CITY OF ALBUQUERQUE

March 3, 2022

**Re: Fiesta Subaru
7100 Lomas Blvd NE
Traffic Circulation Layout
Engineer's Stamp 02-21-2022 (K18-D108A)**

FIRE 1 PLAN

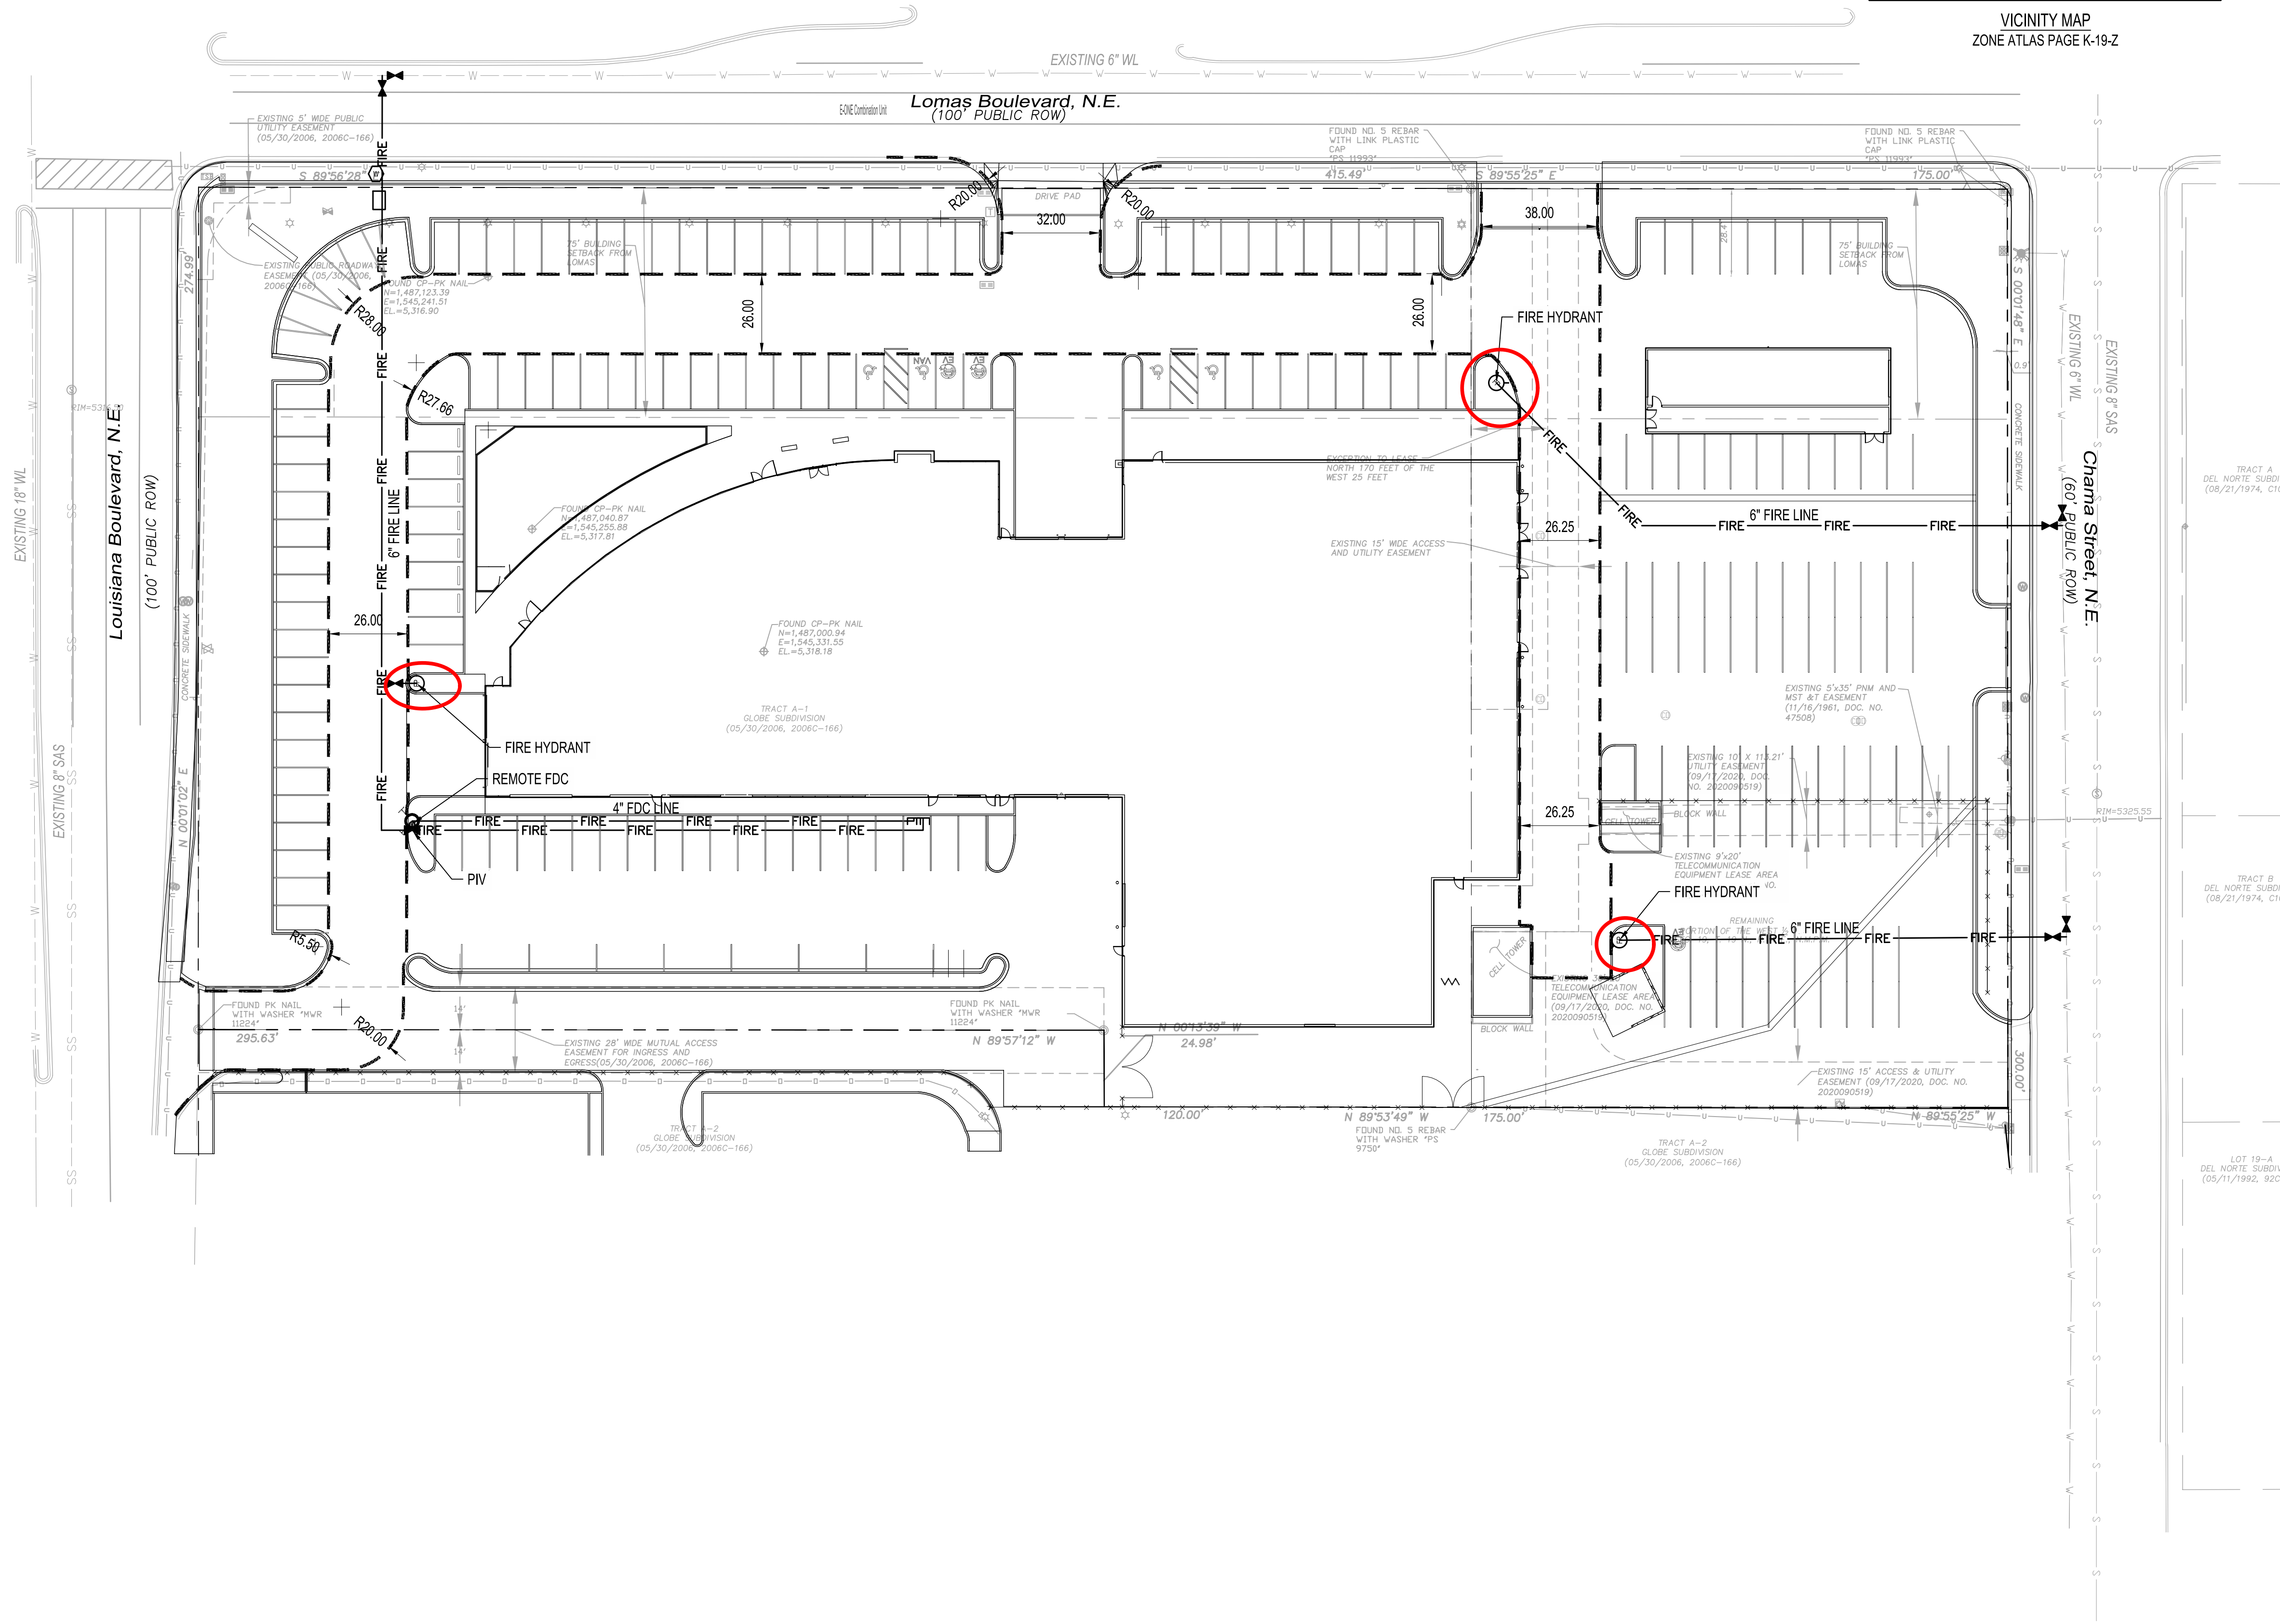
24. Provide a copy of refuse approval.
25. Fire Department: An approval Fire 1 plan needs to be provided.
26. Lomas and Loisiaana: Show the intersection sight distance and add the following note to the plan: "Landscaping and signage will not interfere with clear sight requirements."

SU-30 = Single Unit Truck
Overall Length 30.00ft
Overall Width 8.50ft
Overall Body Height 13.50ft
Max Body Ground Clearance 8.00ft
Lock to Lock 11.00ft
Max Steering Angle (Virtual) 31.80°

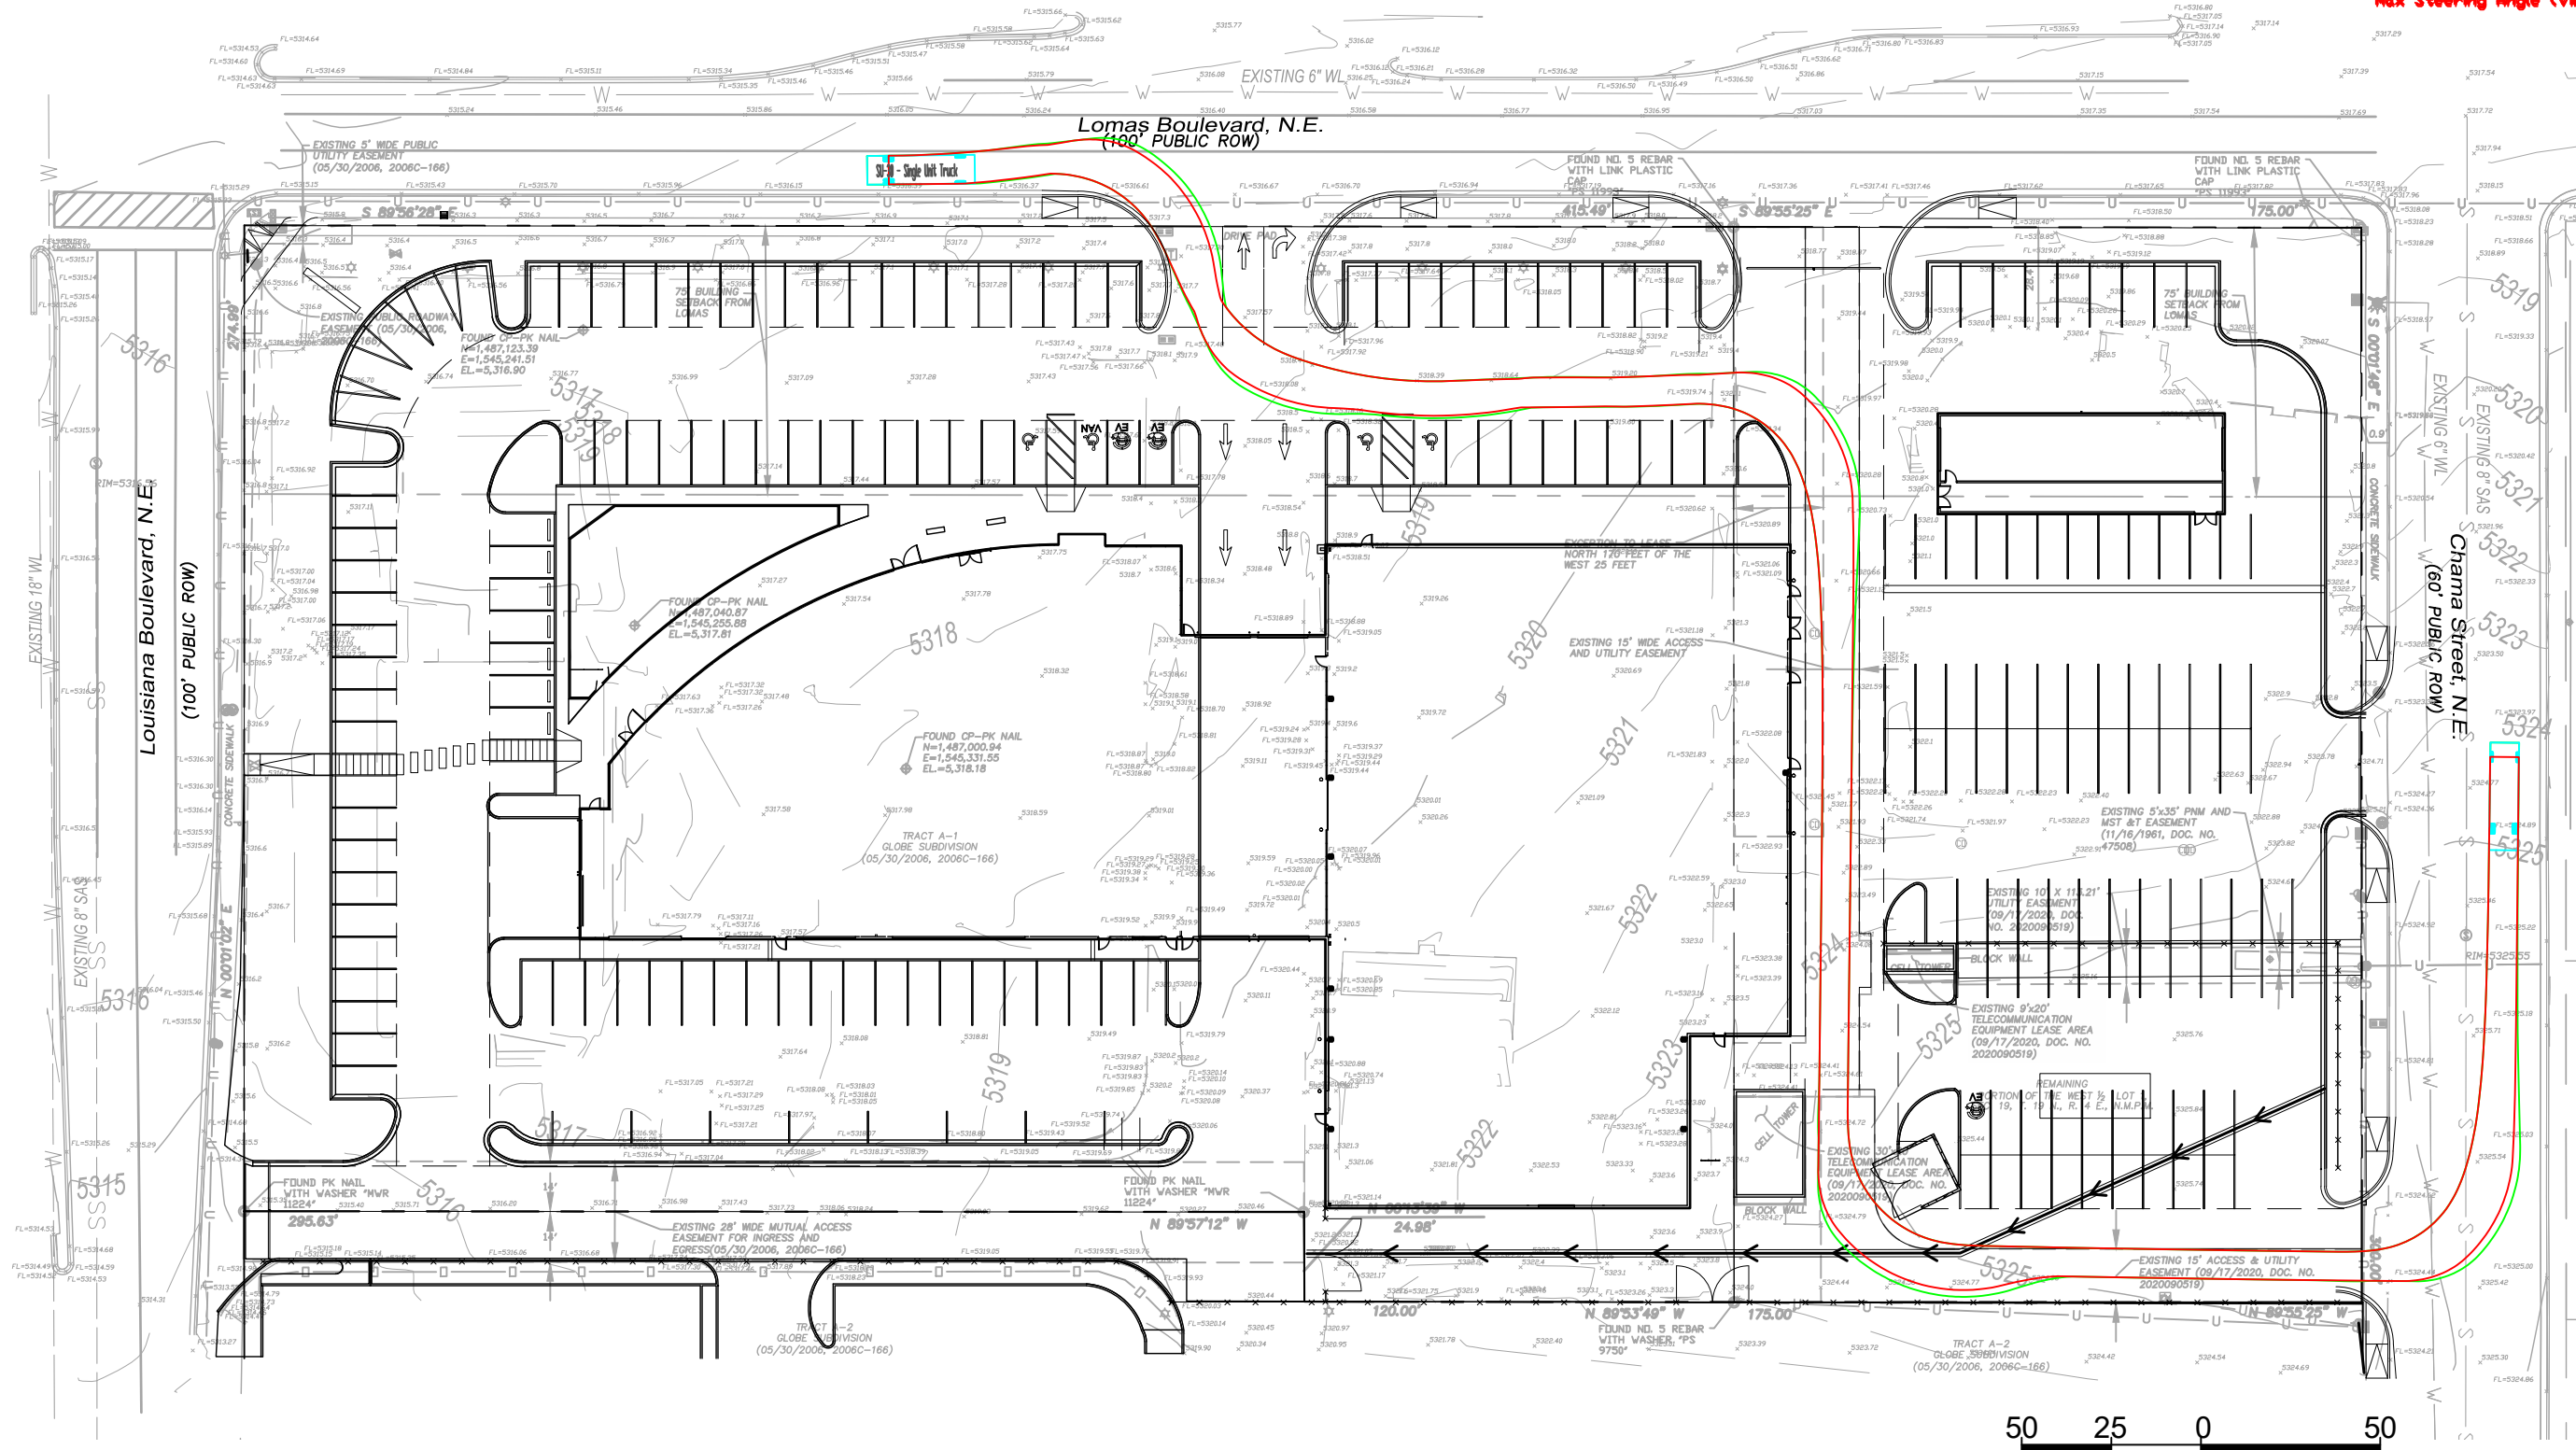
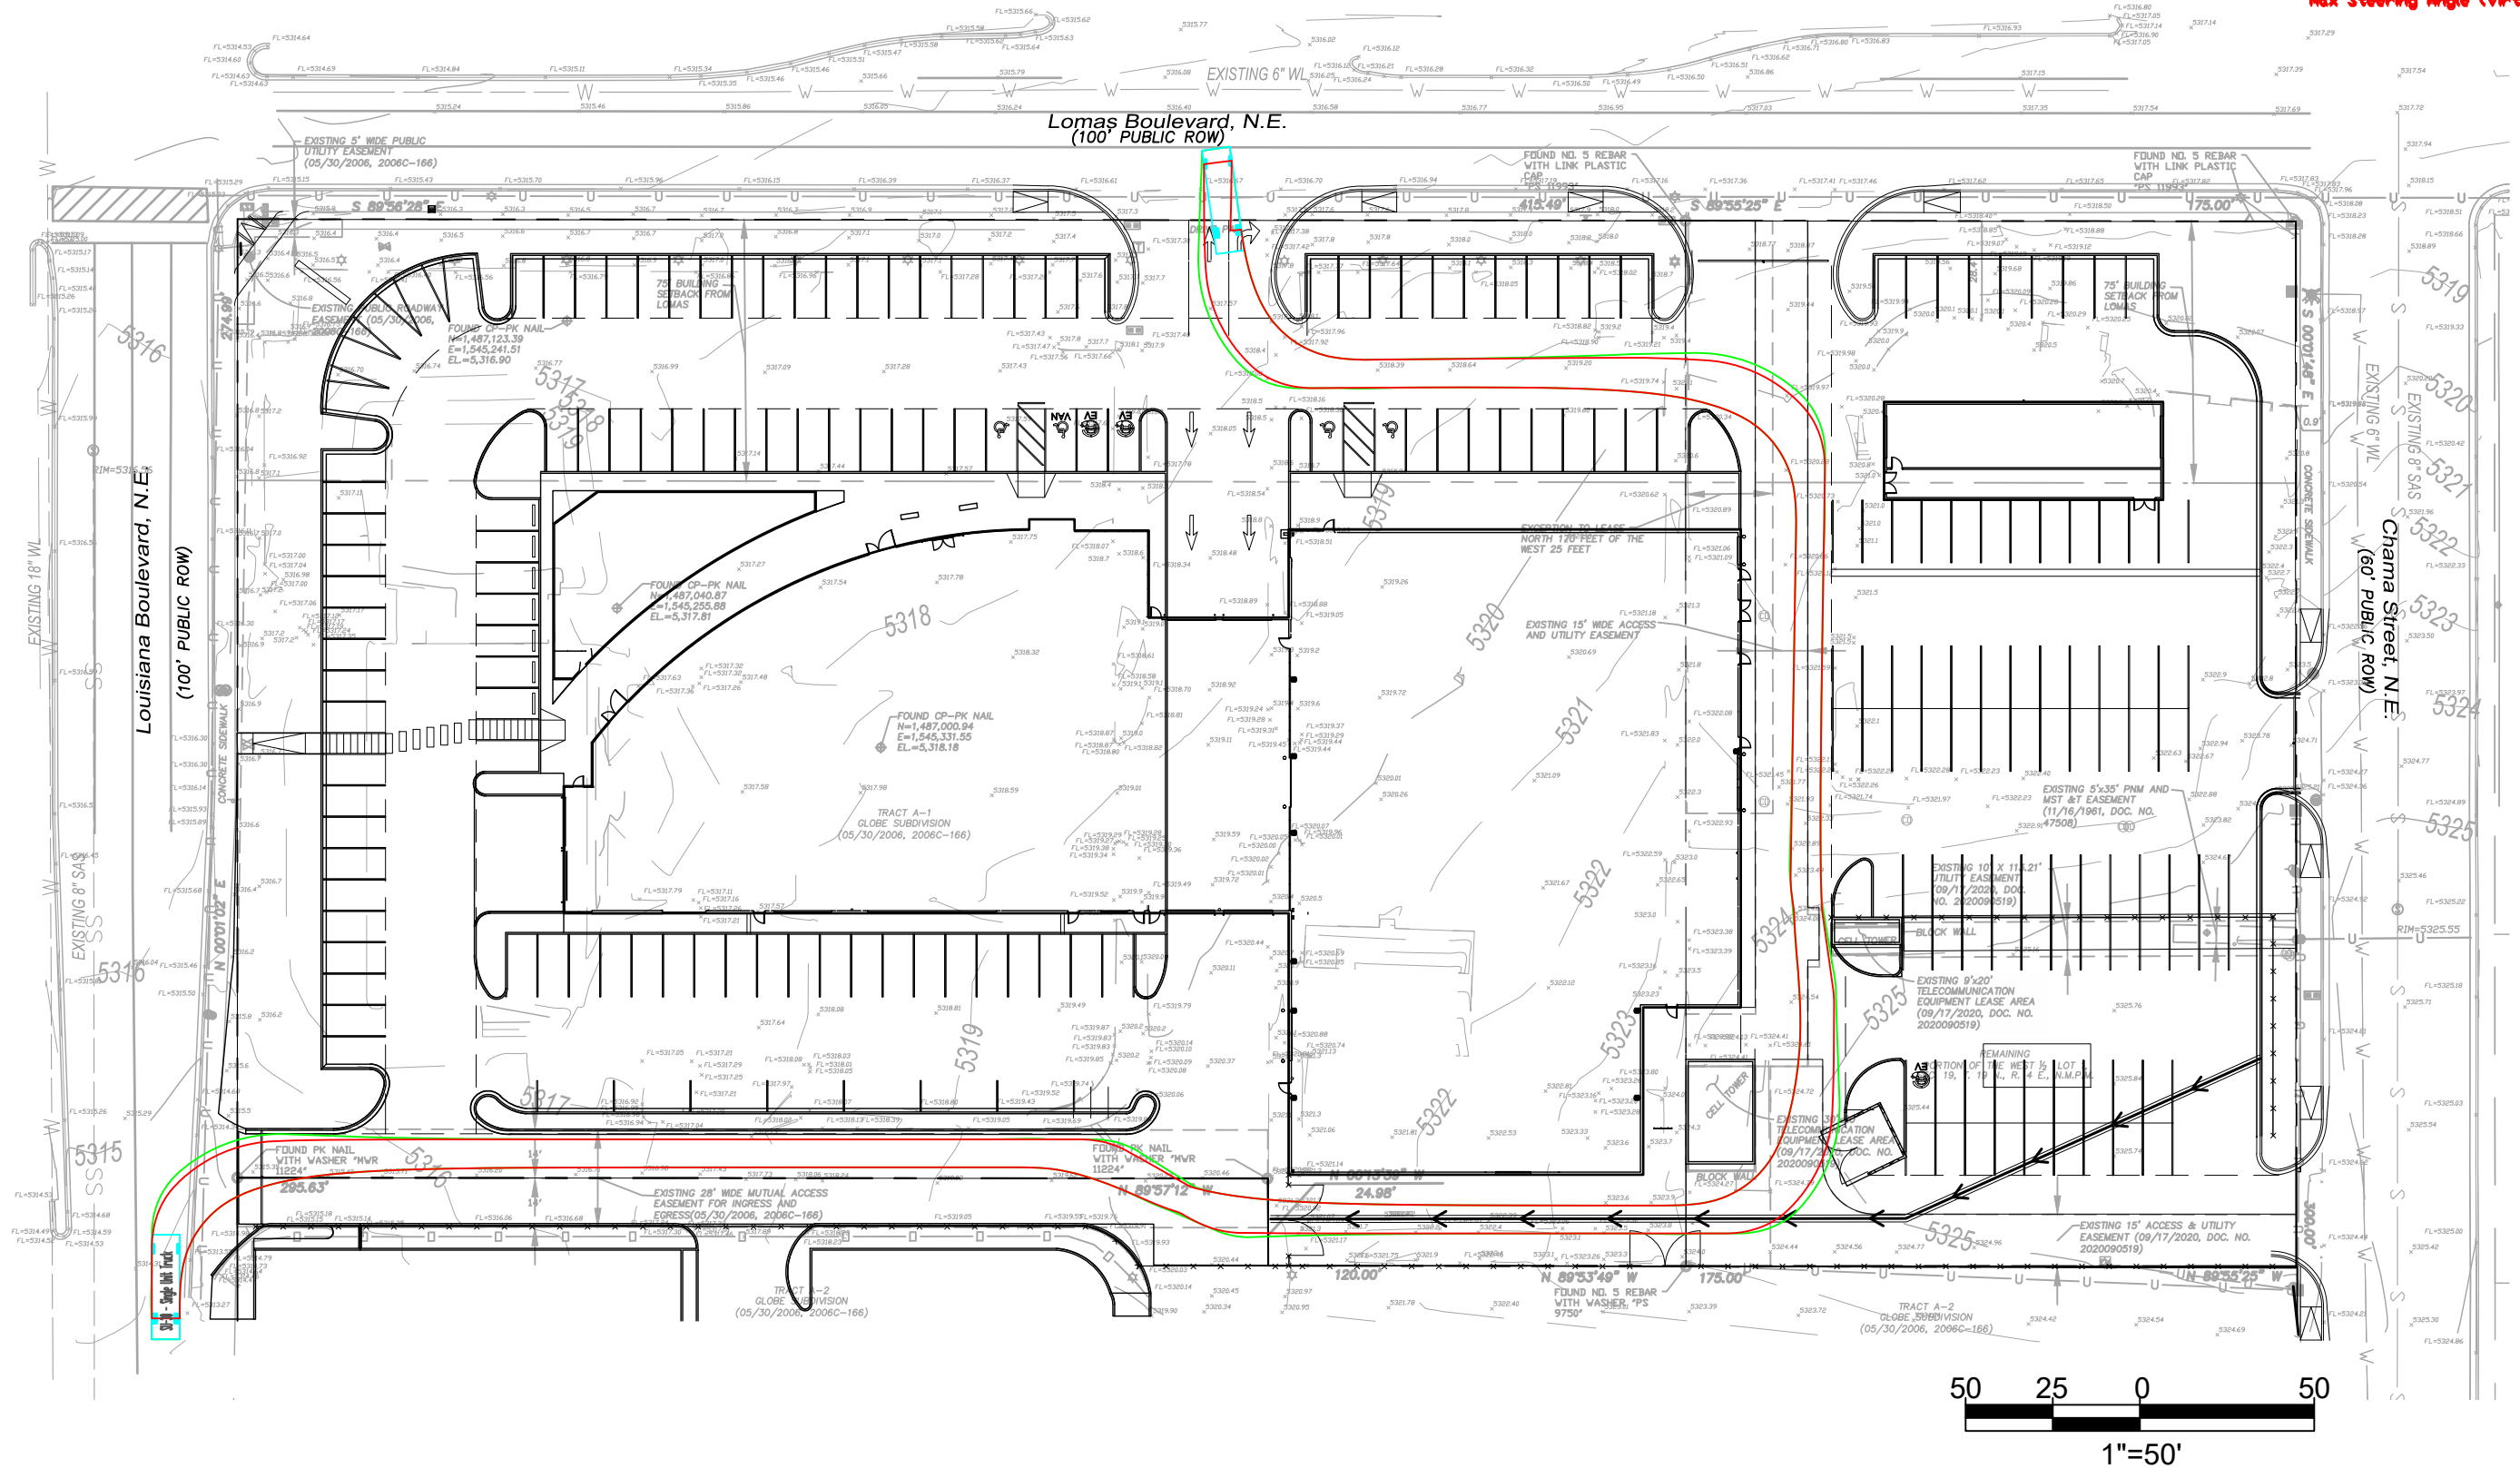
10. A sidewalk easement will be needed at the corner of Louisiana/Lomas to encompass the full size of new ramp.
11. Provide turning templates for delivery vehicle.
